Application Ref:	2026/0194			 Ribble Valley Borough Council www.ribblevalley.gov.uk
Date Inspected:	30/04/2026	Site Notice:	30/04/2026	
Officer:	EP			
DELEGATED ITEM FILE REPORT:				APPROVAL

Development Description:	Proposed construction of garage on existing parking area.
Site Address/Location:	Land to the rear Horton Grange Horton Road Horton BD23 3JT.

Drawing No. 5152_03D

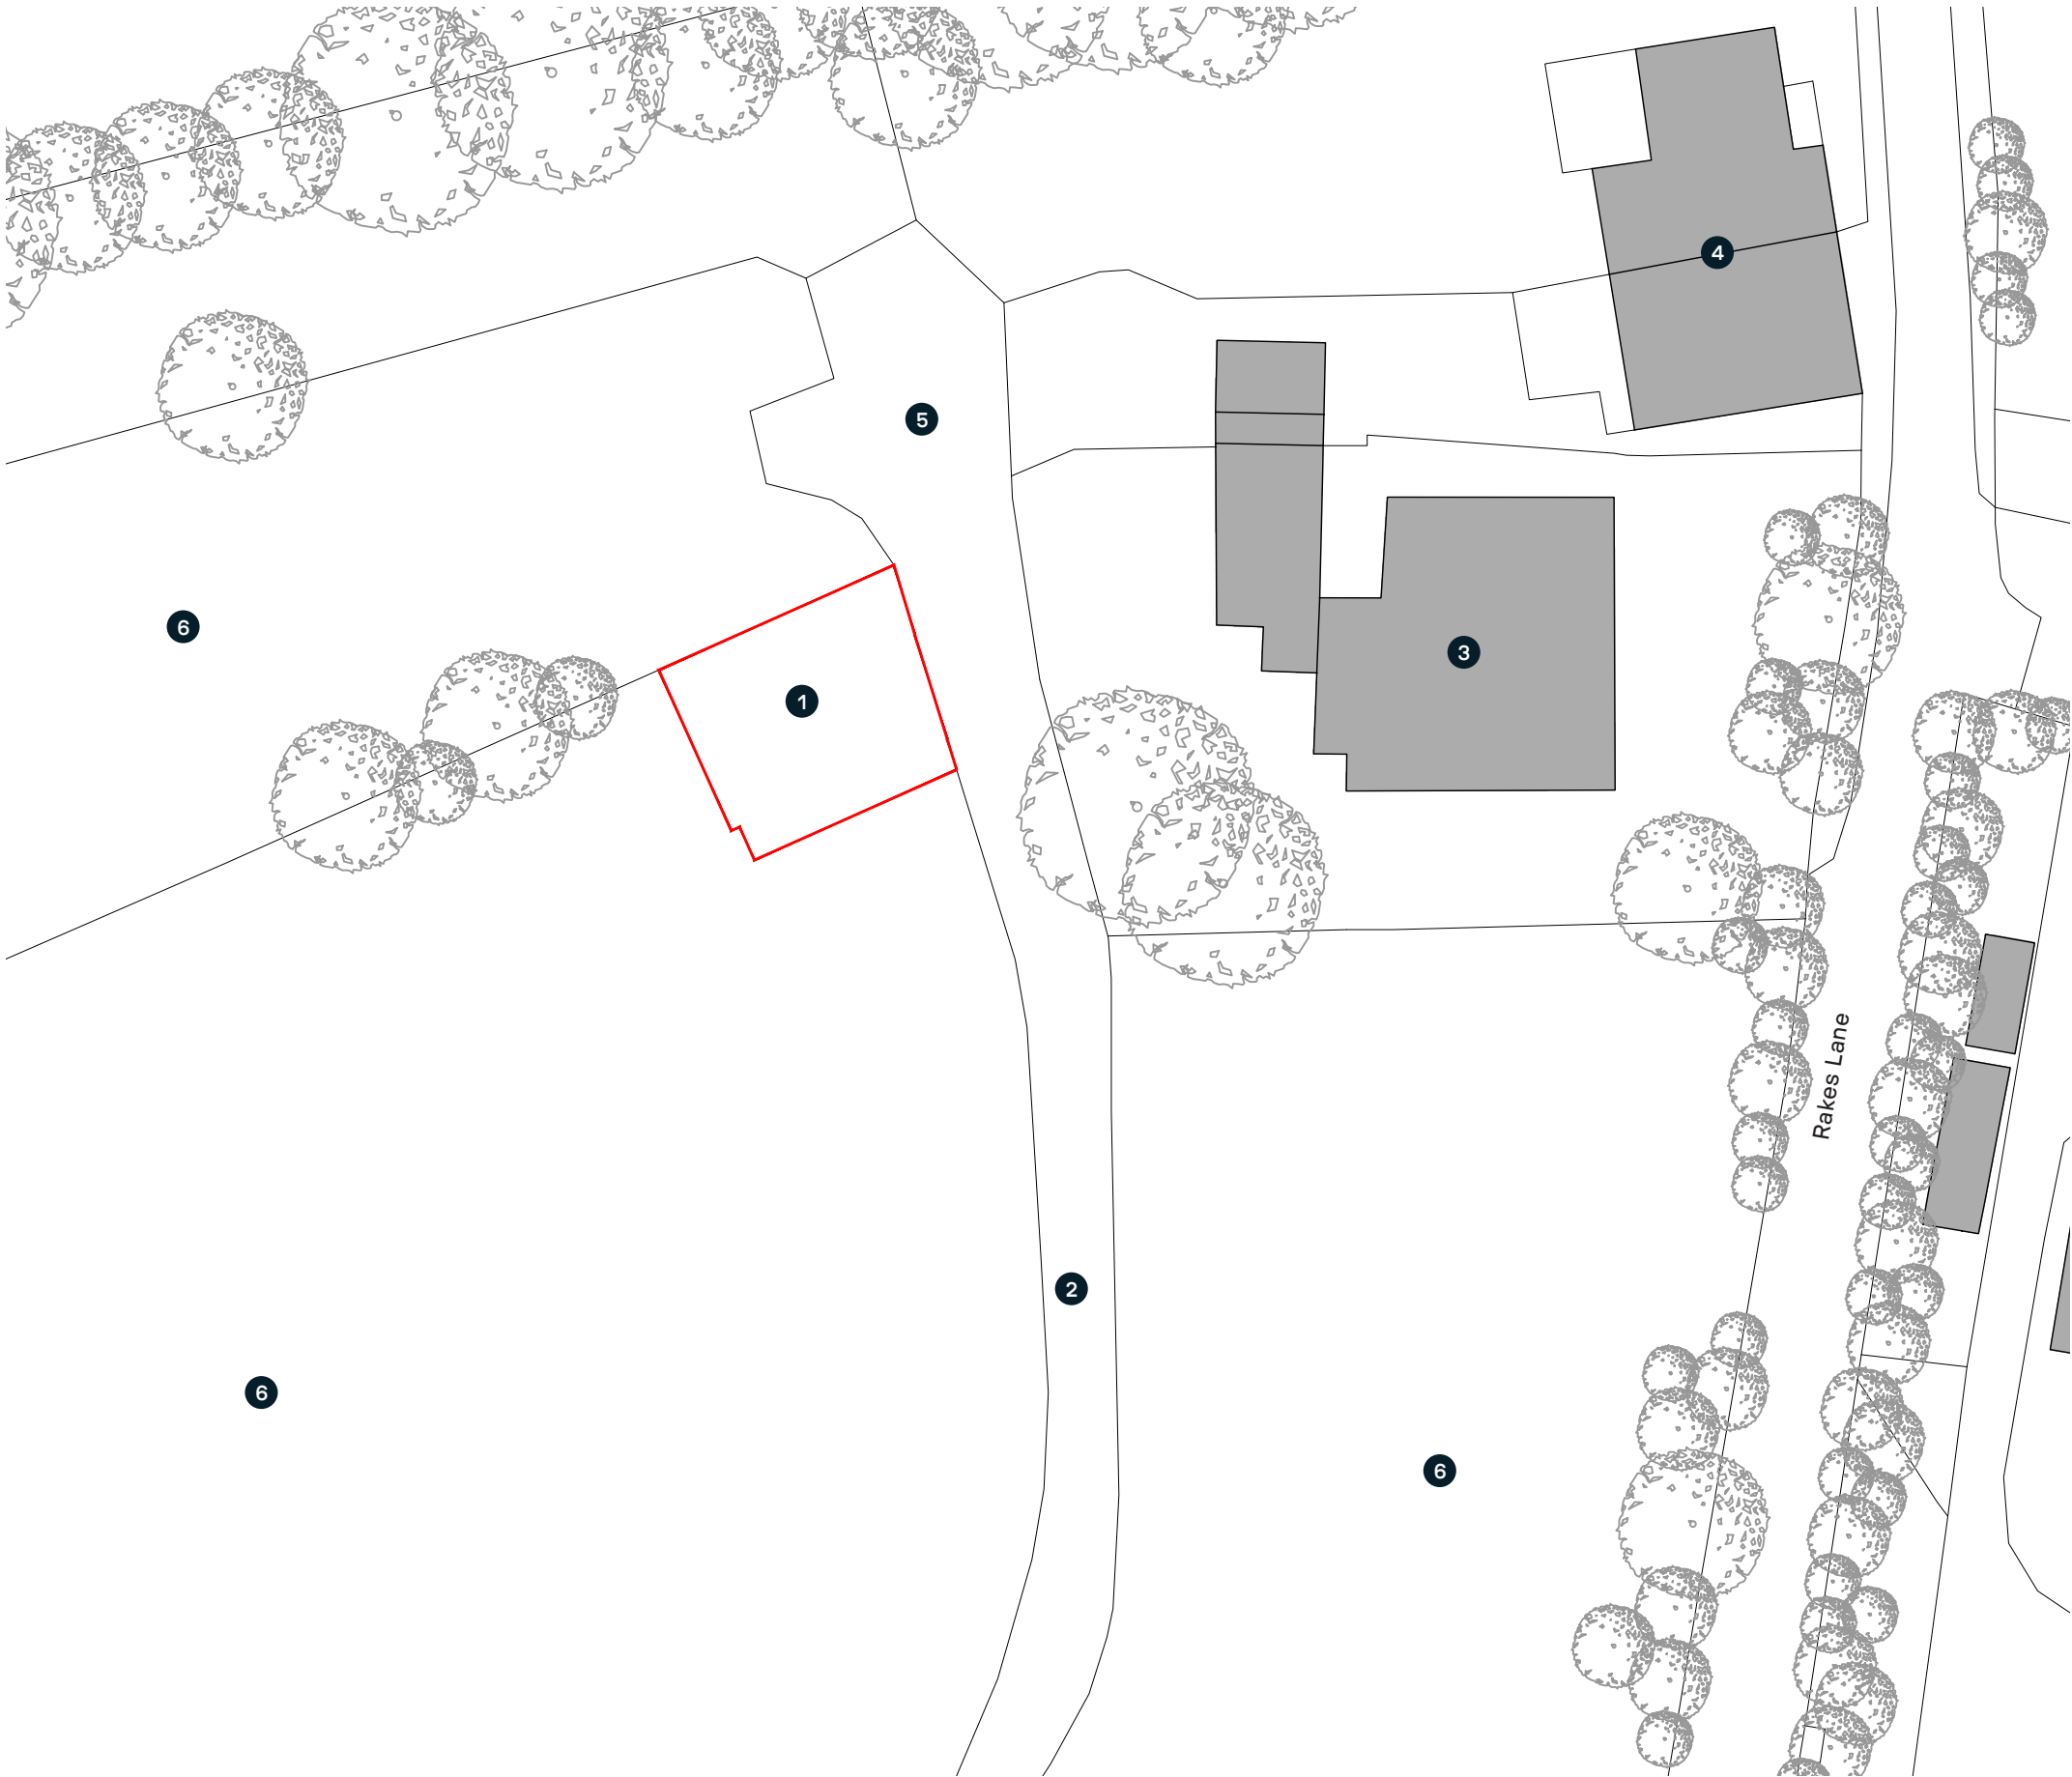
LCC Highways were consulted in relation to the proposed development and raised no objection on highway safety or amenity grounds. Given the garage is adjacent to the shared access road, it was suggested that the building be set away from the road by 2m to mitigate any conflict with road users. An amended plan has been received achieving this set back.

Drawing No. 5152_04C

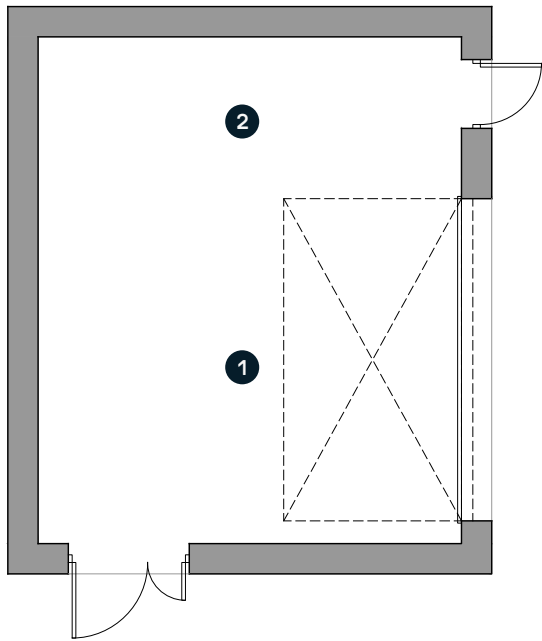
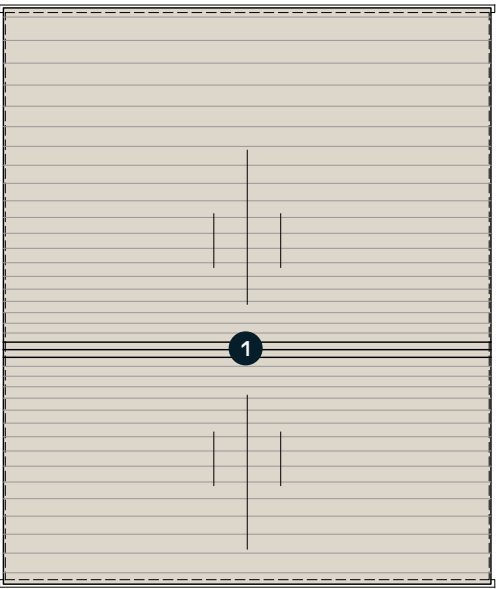
In terms of scale, the original submission was substantially larger in both footprint and height. Following discussion, the scheme has been substantially reduced and now measures approximately 7.5m by 6.5m in length and width, with a reduced eaves height of 2.8m. The structure is now entirely subservient to the application dwelling and other structures on site, being smaller in scale and comparable now to that of standard double garage.

Drawing No. 5152_05C

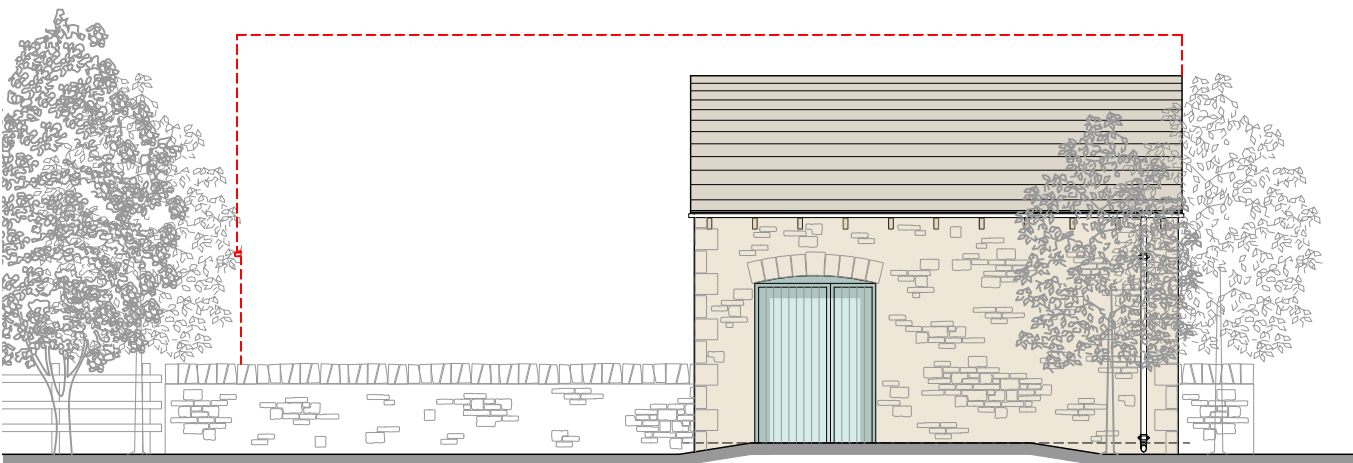
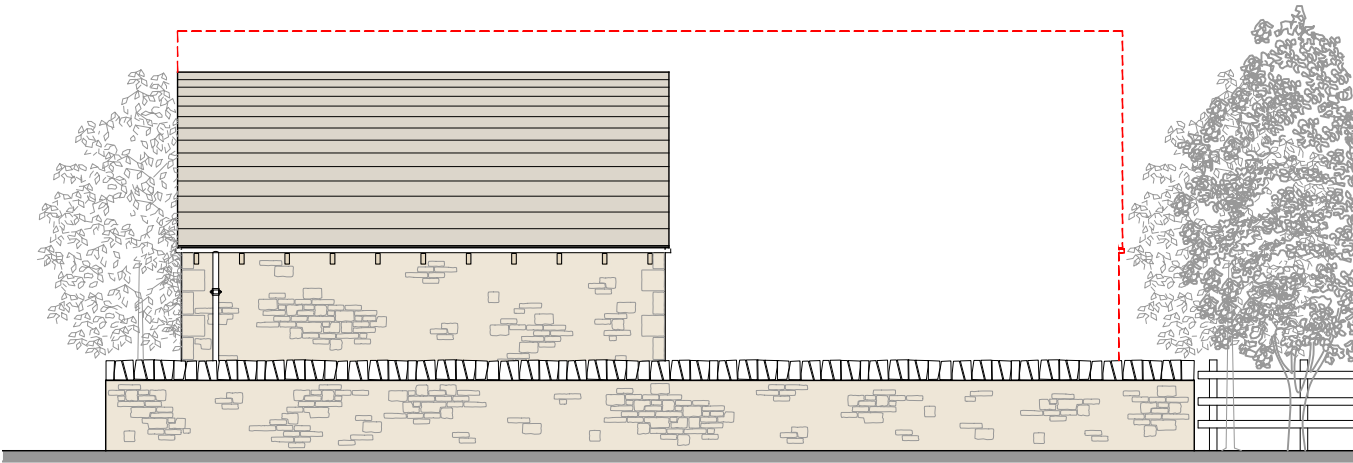
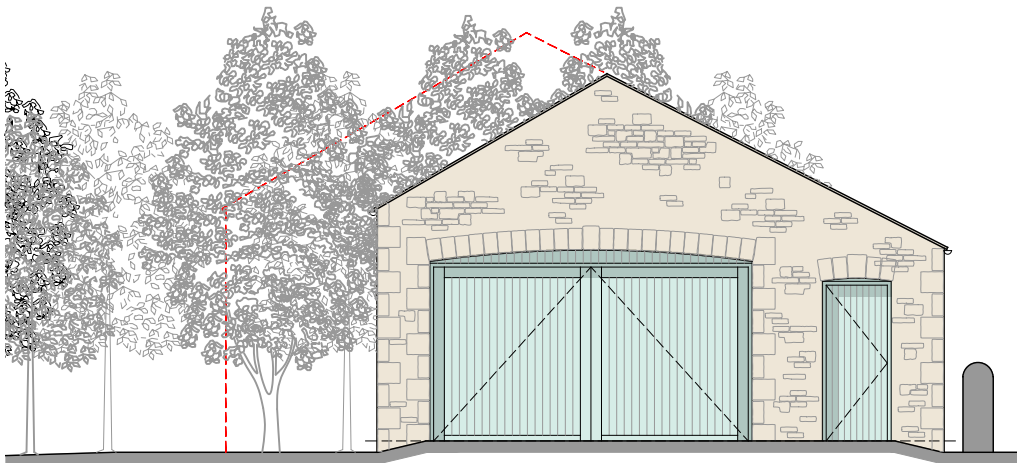
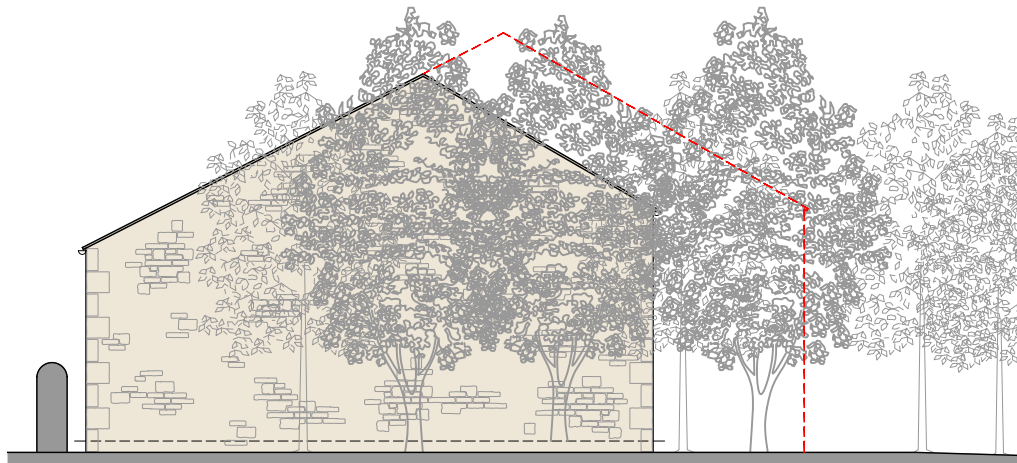
The proposed garage structure is located adjacent to the listed building on a parcel of land recently established lawfully as residential curtilage. The proposed garage has been designed to reflect local vernacular, being constructed of natural coarse stone with painted timber doors. The door openings are arched to reflect the historic character of the adjacent structures. Overall, the design is considered appropriate to the character of the area and will have a neutral impact on the setting of the listed building.
